Thursday, 16 December 2010

Shivesh Singh
Senior Planner
Department of Planning
Strategic Assessment
23-33 Bridge Street,
Sydney NSW 2000

**RE: SCOTTISH HOSPITAL REDEVELOPMENT,
2 COOPER STREET, PADDINGTON
Ref MP10_0016**

DRAWING No
DA233

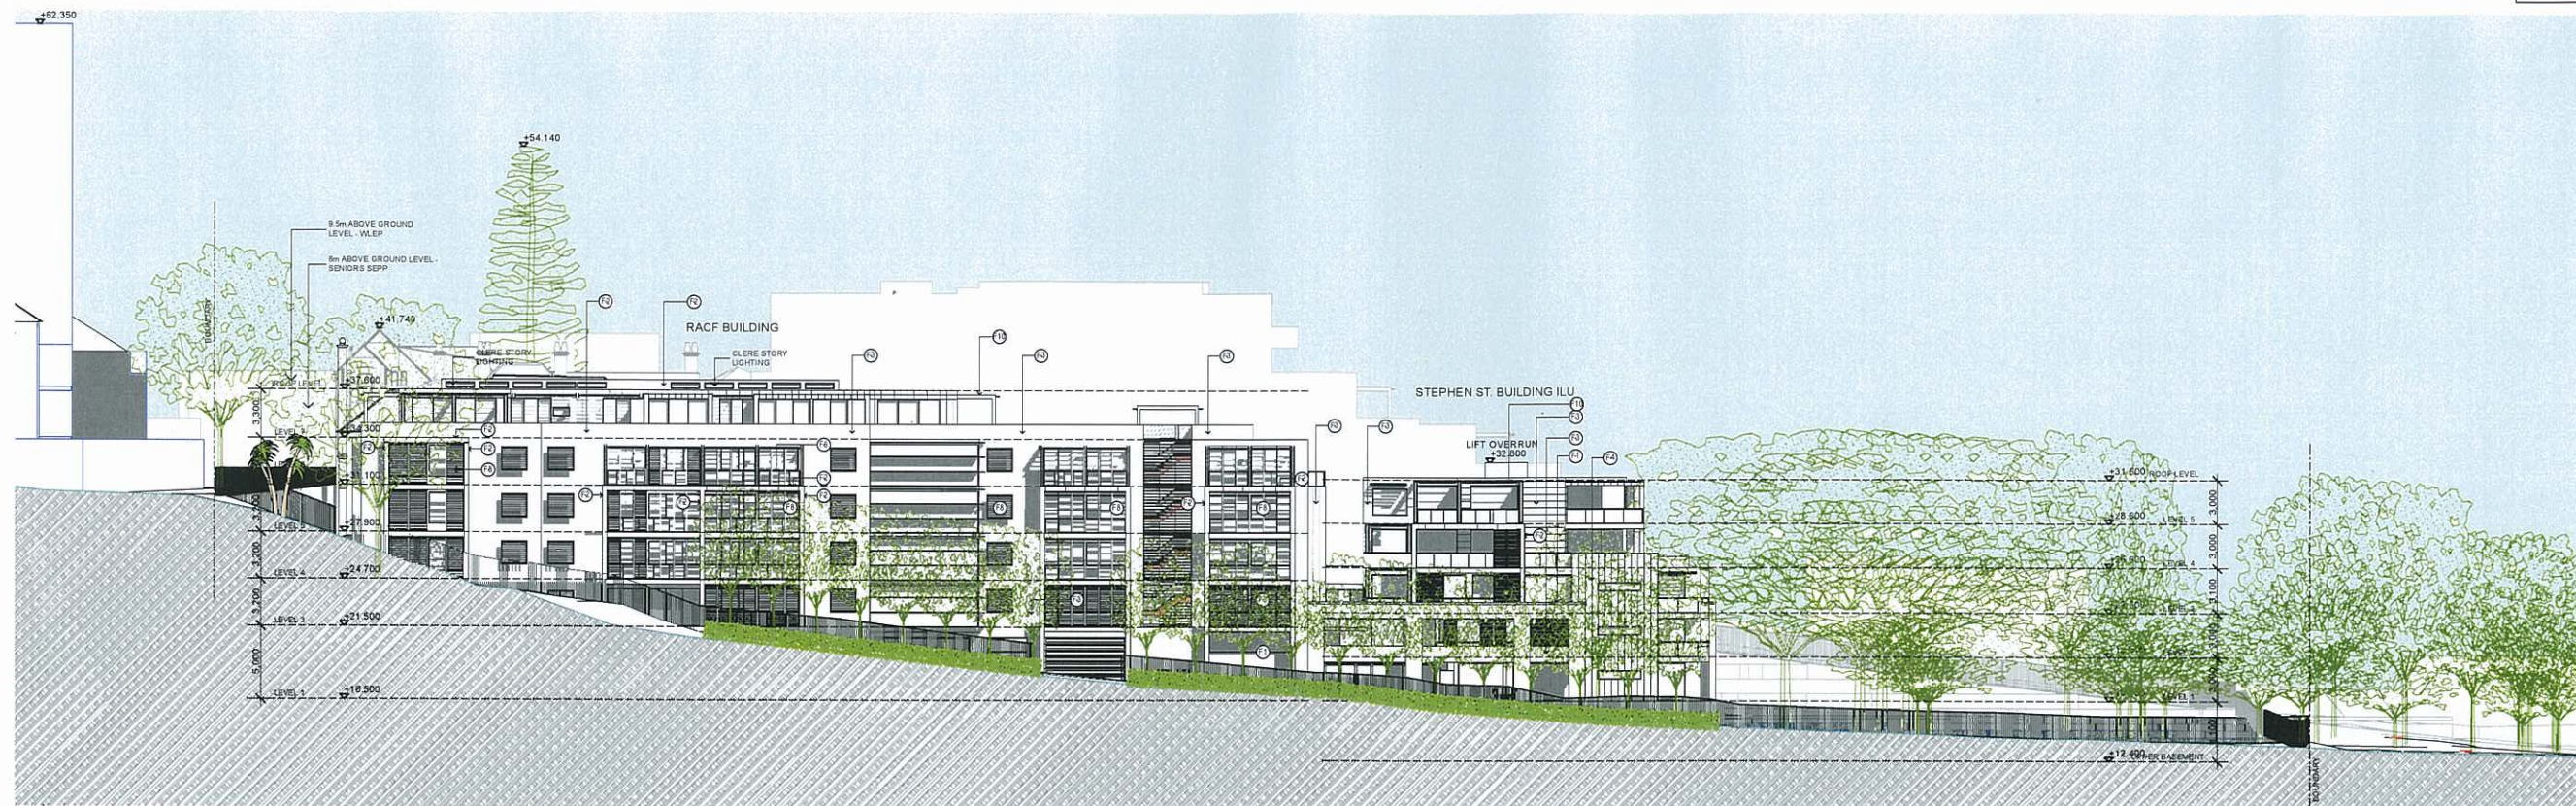
The new wing along Stephen Street directly impacts our property, which is adjacent to the Cooper/ Stephen Street corner, in two ways. Firstly, the additional storey, Level 7 of the new Stephen Street wing will cast a new shadow across my backyard over my swimming pool at 3pm on the Winter Solstice 21 June (refer to JPR Architect's drawing DA512A). Secondly, the large areas of south eastern windows & the large wrap around terrace on the additional storey, Level 7 of the new Stephen Street wing will overlook our backyard & into our bedroom and bathroom windows along our north western elevation (refer attached plan). Thirdly, the creation of the service access to the top of Stephen Street will create traffic noise from service trucks entering & leaving the building up to our backyard above especially because of the natural amphitheatre to the top of Stephen Street has an amplified effect on noise from the street below.

The development's relationship to the original heritage component of the Scottish Hospital is completely non existence. The sitting relationship is very poor to the eastern side of the Scottish Hospital to the new Stephen Street wing. The single storey 1900 pitch roofed wing abuts a two storey contemporary box with the new two storey box out scaling the original heritage wing. It should be the other way around. The single storey wing off the Scottish Hospital should be enhanced by the new wing not destroyed by it. The scale of the new Stephen Street wing should remain single storey with a pitched roof as it currently is. This would keep it in scale with the existing heritage wing of the Hospital & the adjacent single storey street fronted cottages of No.4, 6 & 8 along the lower side of Cooper Street.
